Application Number: 2014-124 **Application Date:** 07/09/2014
CBL: 073 A001001 **Application Type:** Zoning Contract/Conditional Rezoni
Project Name: Mercy Master Plan Update
Address: 175- FORE RIVER PARKWAY
Project Description: Update to the Master Plan to include Phase II Hospital relocation and expansion.

**Subject: Mercy at the Fore
195 Fore River Parkway
Applicant: Mercy Hospital
Contract Zoning Agreement Amendment**

**Subject: Mercy at the Fore
195 Fore River Parkway
Applicant: Mercy Hospital
Contract Zoning Agreement Amendment**

2014 Proposed Overall Site Plan (also in Plan P5):

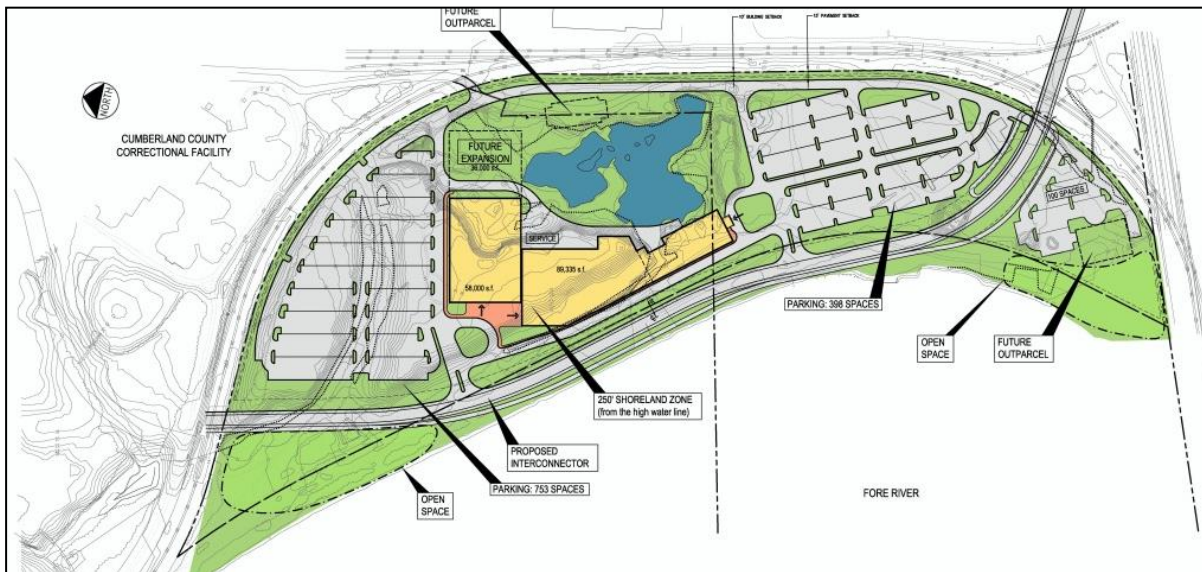
A Master Plan (similar to the 2001 Concept Plan) that includes and identifies the already completed phases as well as future phases so one can see the overall final build out; and

The data as related to what was approved in 2001 Master Plan (all phases); what was approved in the 2006 Master Plan (all phases) and what is proposed now in the amended Master Plan (all

phases, including already completed Phase 1). We would like to understand whether any of the associated data (e.g. floor area, parking requirements; trip generation, etc.) are now increased in the latest Master Plan as compared to the 2001 Plan attached to the CZA. For example, does the TMP in place cover all of the proposed traffic from the amended Master Plan (all phases)?

So we are requesting a single "master plan" that is comparable to the 2001 and 2006 plans showing all phases on one plan; and a data table that sets out the following information (what was permitted, consistent with what was represented on the master plans) for each of the three Master Plans (2001 Master Plan as attached to the approved CZA; 2006 Master Plan all phases; proposed amended Master Plan - all phases):

As part of the July 7, 2014 submission we had included Plate 2, the Overall Site Plan, which depicts the full build out scenario currently contemplated by Mercy Hospital. This plan, in its current form or modified, as to be determined through this current review process, will serve as the Amended Master Plan moving forward. We are open to working with you on the best means of presenting the Master Plan, given the complexity and size of the Mercy at the Fore development. As you know, the Mercy Master Plan has evolved from a single sheet drawing in 2001 to a multiple sheet series of plans (2006) covering various aspects of the site. As discussed further below, it is worthwhile to present a summary comparison of the Mercy's development plans as it existed and was approved in 2001, subsequently amended in 2006 and as is now proposed. A tabular presentation of this information has been prepared and accompanies this letter.

The accompanying table (*Table 1 Master Plan Comparison Data*) has been prepared as a summary of the information outlined above. We trust this informational form helps simplify the overall history of the site and the planning path that Mercy has followed over time. Clearly there are some aspects of the project moving forward that will require updated permitting, including the Traffic Movement Permit with the DOT and the Site Plan review with the City. However, despite the increased development program, we are confident that Mercy's current plans remain well within the land use and development intensity contemplated by the original CZA and Master Plan. Based on the site conditions in place we believe that Mercy's plans continue to
